Re: **46a Sea Lane, Middleton-on-Sea M/153/18/PL**

Representations of Middleton on Sea Association in respect of Planning Application

M/153/18/PL - Land adjacent to 46 Sea Lane, Middleton on Sea.

Proposed East Elevation in Context 1:200@ A3

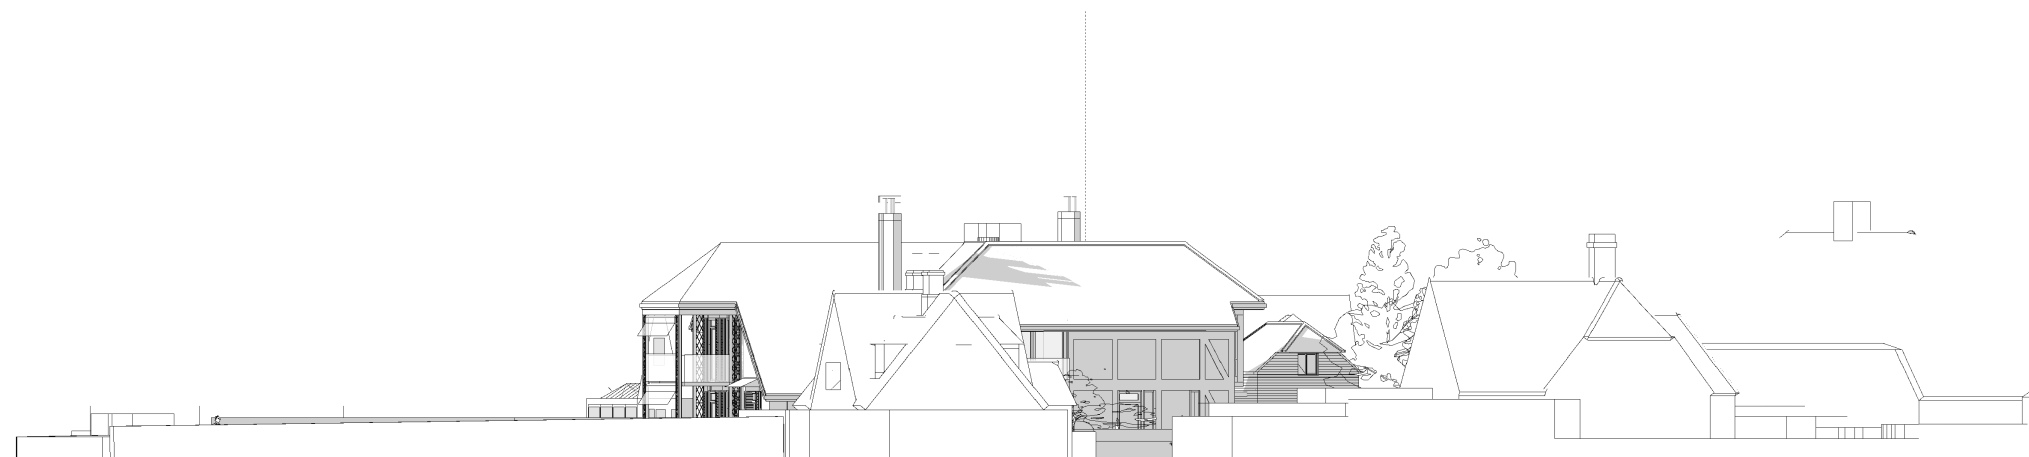
Firstly, the existing and proposed eastern elevations in context are significantly misleading being taken from an unrepresentative and non-public viewpoint to the east of Bywater House and 2 Old Point, (ie from a viewpoint on the south side of properties within Old Point) rather than from a location on Sea Lane. This gives a very false impression of the scale and massing of existing buildings that form the relevant setting and backdrop to the proposed development located as it is on the western side of Sea Lane. However this drawing, when seen in that context also serves to highlight how unrepresentative and overbearing the proposed development (in height, scale and massing) would be when compared to 46 Sea Lane, Bywater House and 2 Old Point and when seen in the context of the compact plot on which it is sited.

Furthermore the elevation drawings show a significant increase in the massing of the dwelling alongside Sea Lane, compared to that previously proposed including a significant reduction in the open space buffer between the eastern facade and Sea Lane thereby resulting in a dramatic change to the street scene at this point.

Roof Plan 1:100 @A3

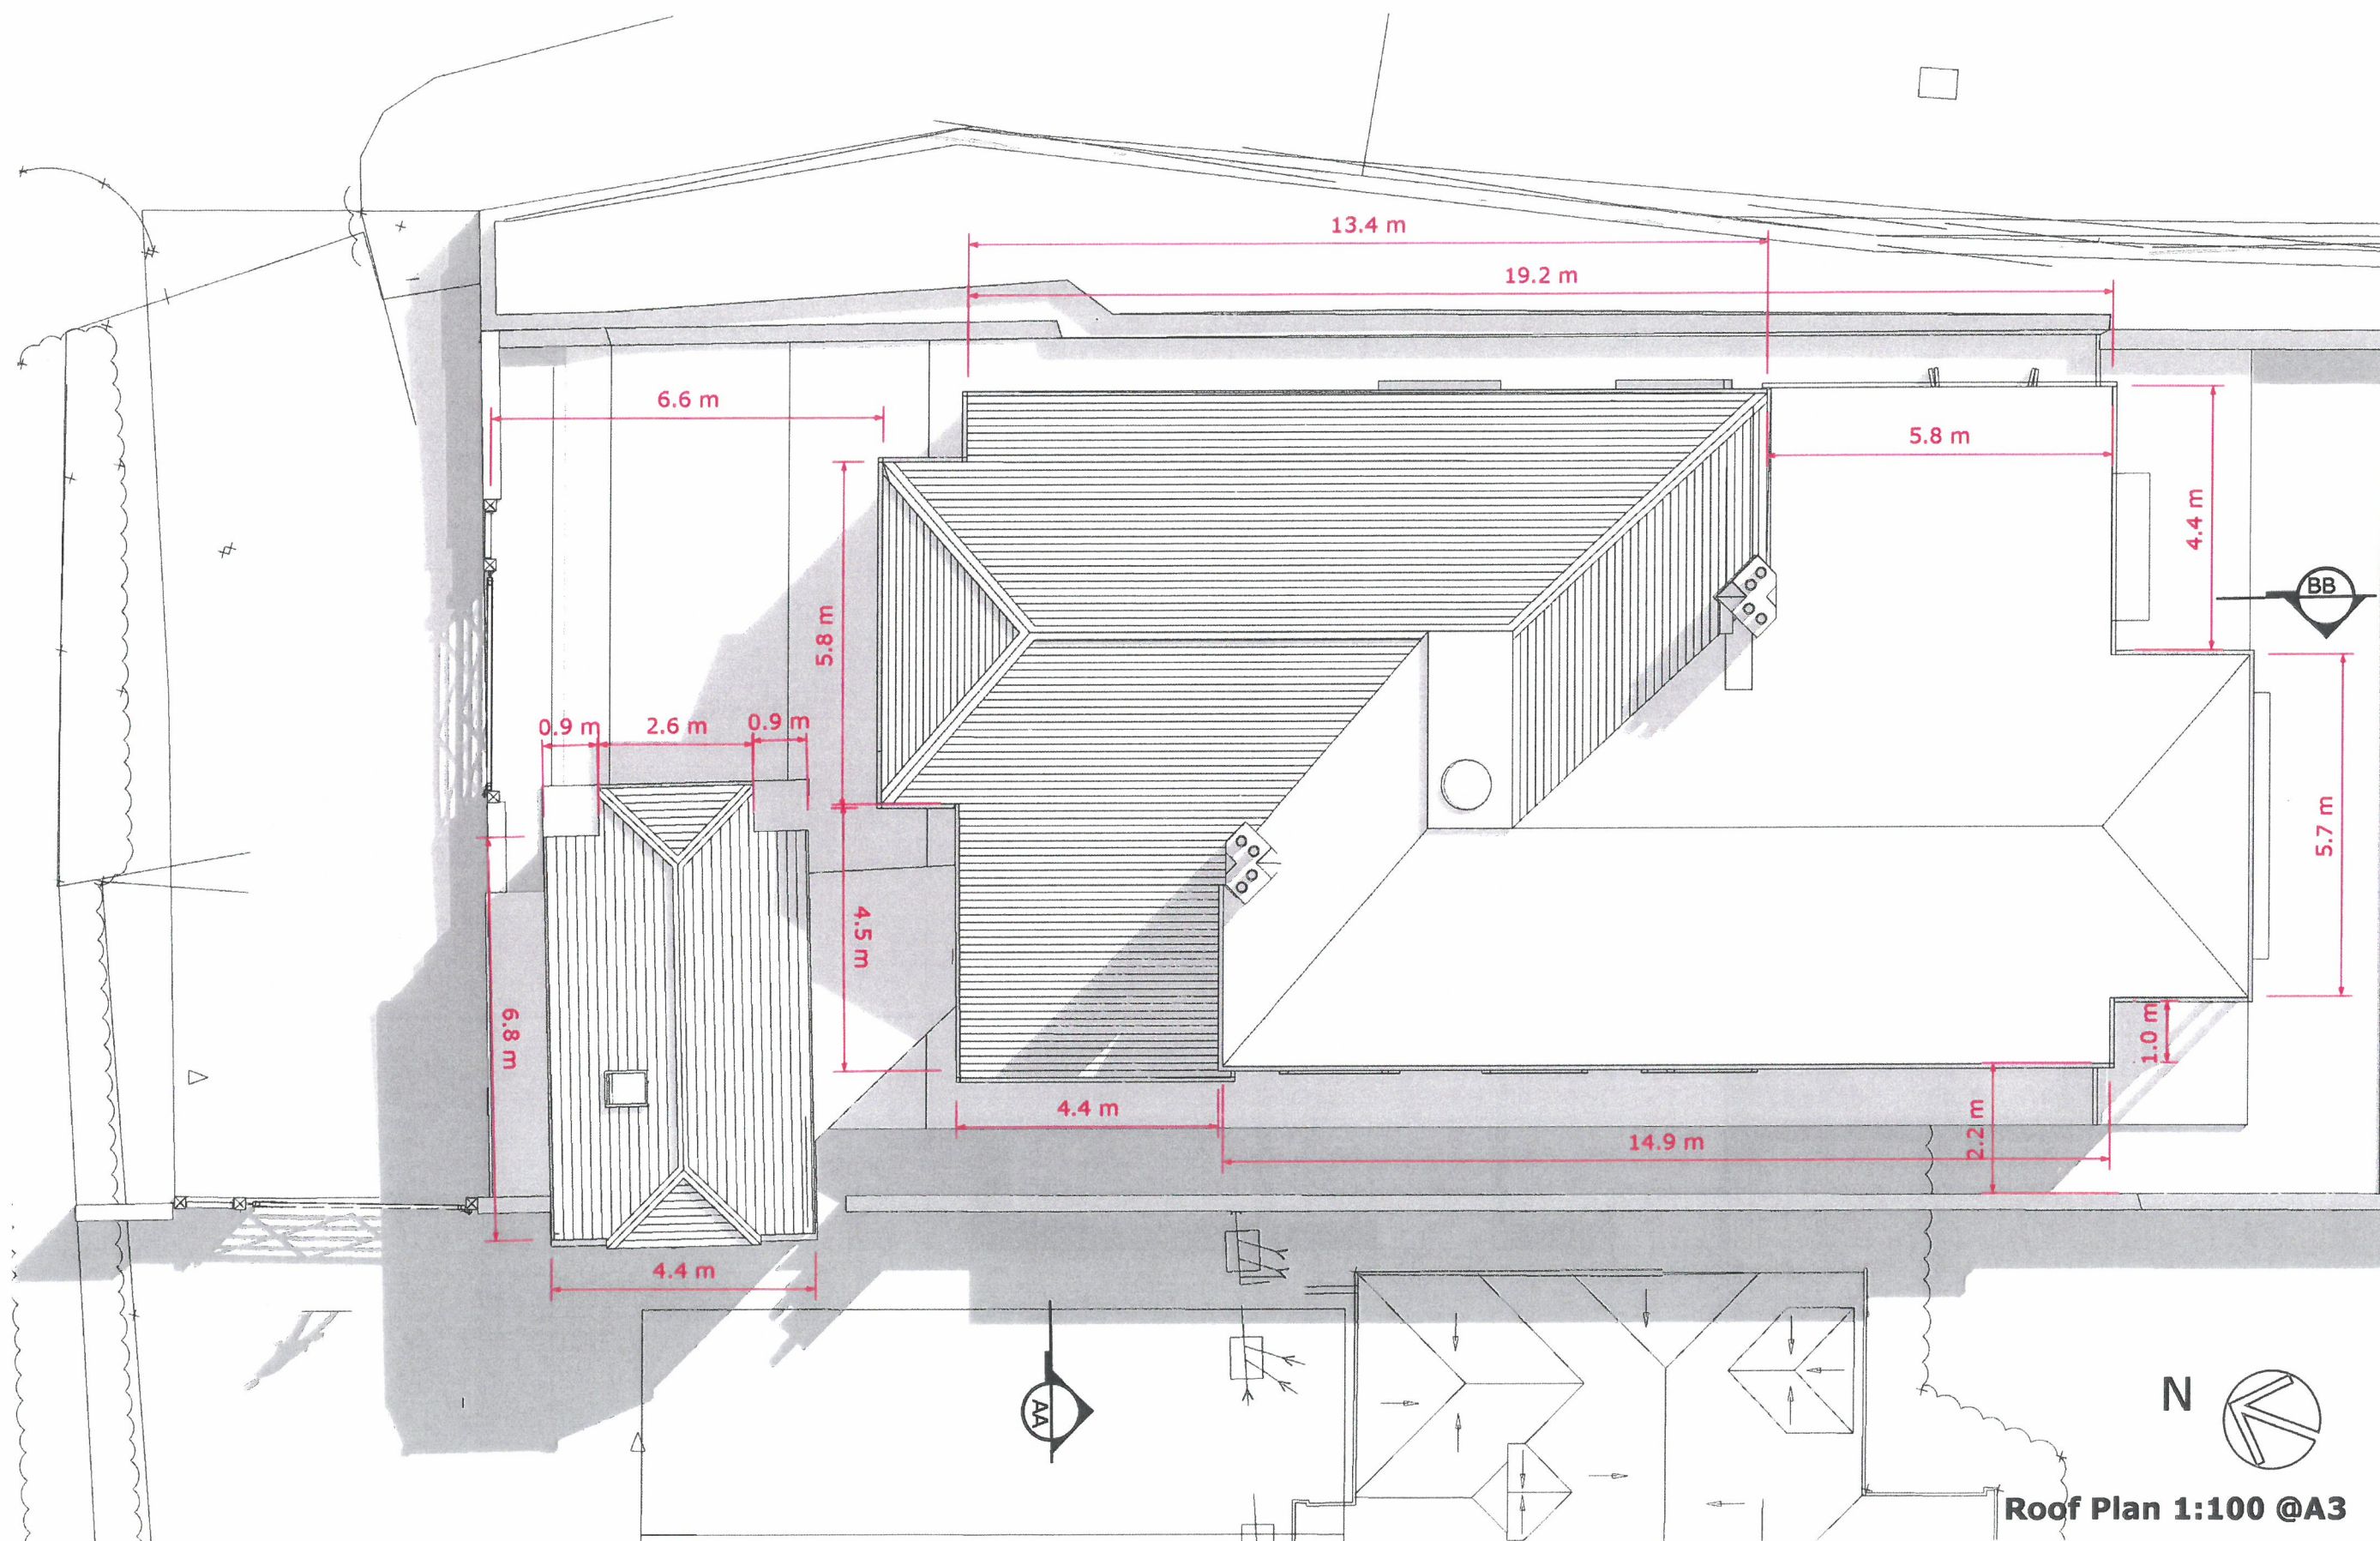
Secondly, the plot size and building footprint sizes stated in the application give a false impression of a low density development particularly when this is contrasted with the Block Plan and roof plan submitted. This is because of the significant roof projections that enclose the spacious balconies/terraces to the north and south elevations, resulting in a significant increase in the scale, height and massing of the buildings compared to the development previously approved. In addition the floorspace of the proposed dwelling represents a 50% increase (some 100 sq m) over the development previously proposed.
